**APPEAL AGAINST CHERWELL DISTRICT COUNCIL FOR THE
DEVELOPMENT OF**

**LAND AT NORTH WEST BICESTER, CHARLOTTE AVENUE,
BICESTER, OX27 8BP**

REBUTTAL PROOF OF EVIDENCE

PLANNING INSPECTORATE REFERENCE: APP/C3105/W/23/3315849
CHERWELL DISTRICT COUNCIL REFERENCE: 21/01630/OUT

Date:
30/05/2023
Diagram:
7 - Rev A

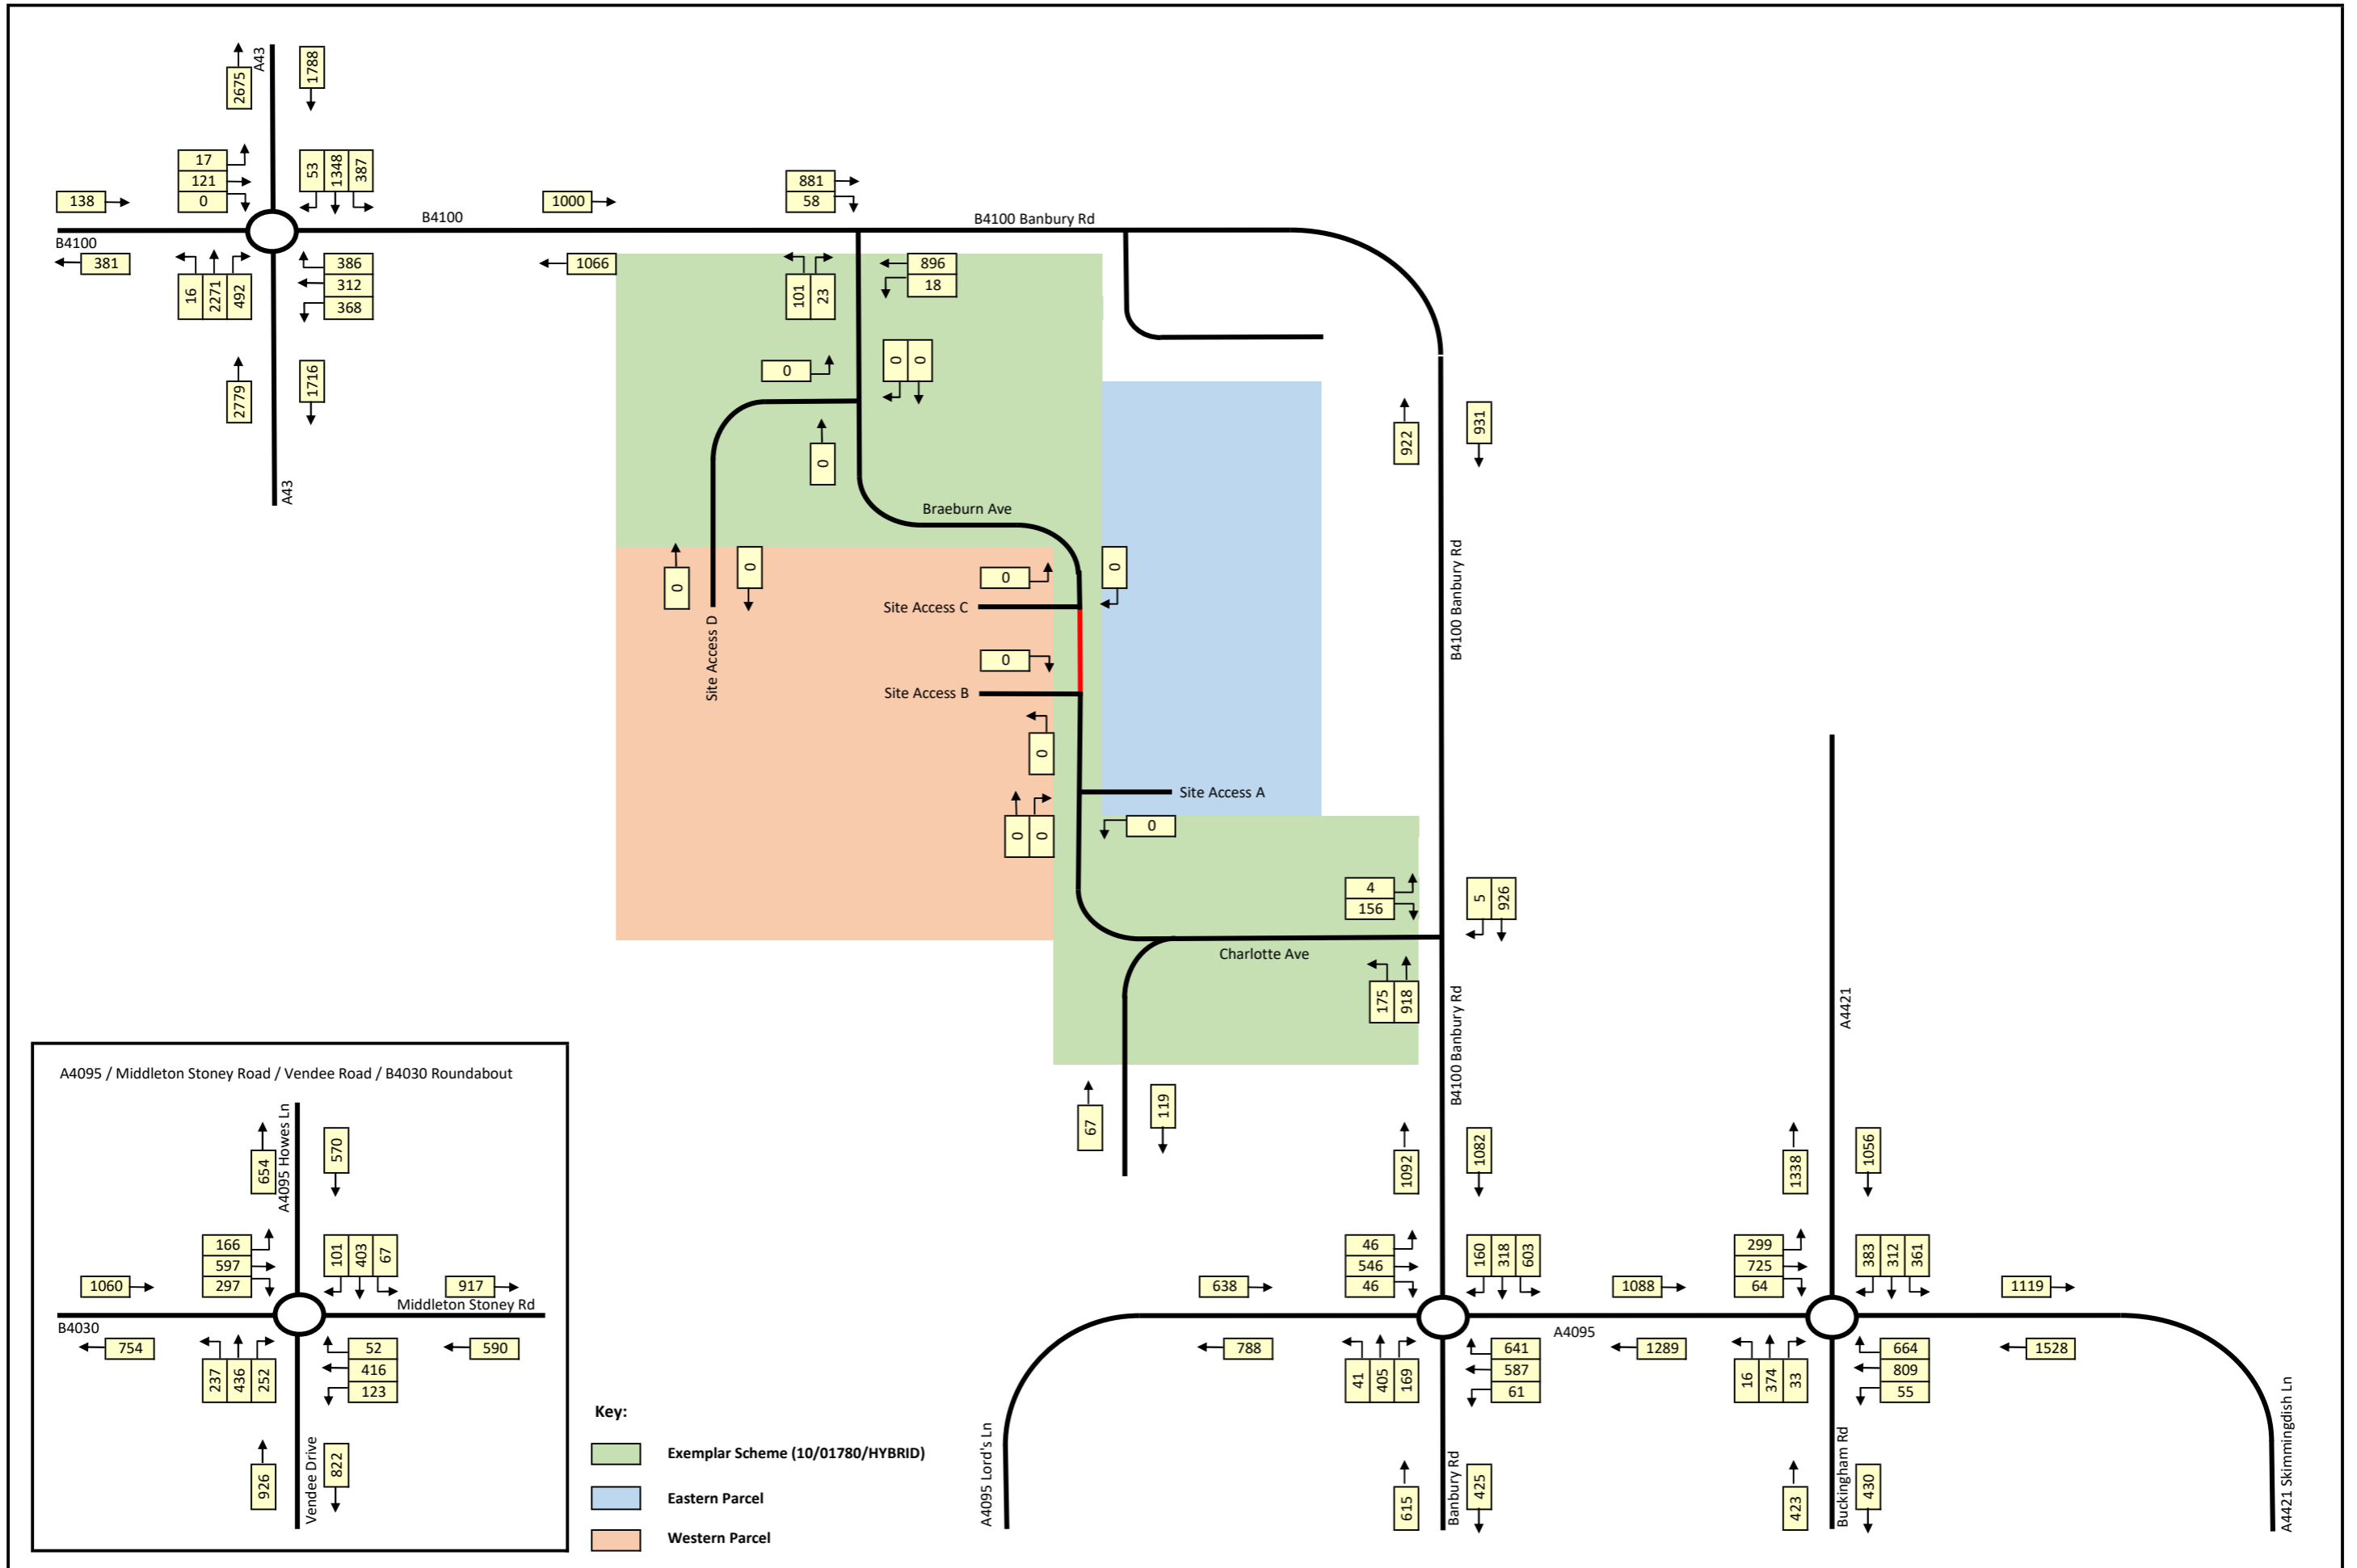
- (b) Diagrams 6 & 7 – 2031 Base Traffic Flows
- (i) Based on the methodology set out above, as the level of traffic associated with the Exemplar Development must be consistent, and the 2031 BTM traffic flows do not include the Proposed Development, the difference has been

assumed to be associated with traffic flows related to the adjacent Hawkwell Village Development (Planning Ref: 21/04275/OUT), the Primary School, and other consented uses on the Exemplar Development (phases 1 & 2).

- (ii) These traffic flows are 'assigned' to Cranberry Avenue so as to specifically identify them, even though they are not assessed in detail.
 - (c) Diagrams 4 & 5 – Proposed Development Traffic Flows
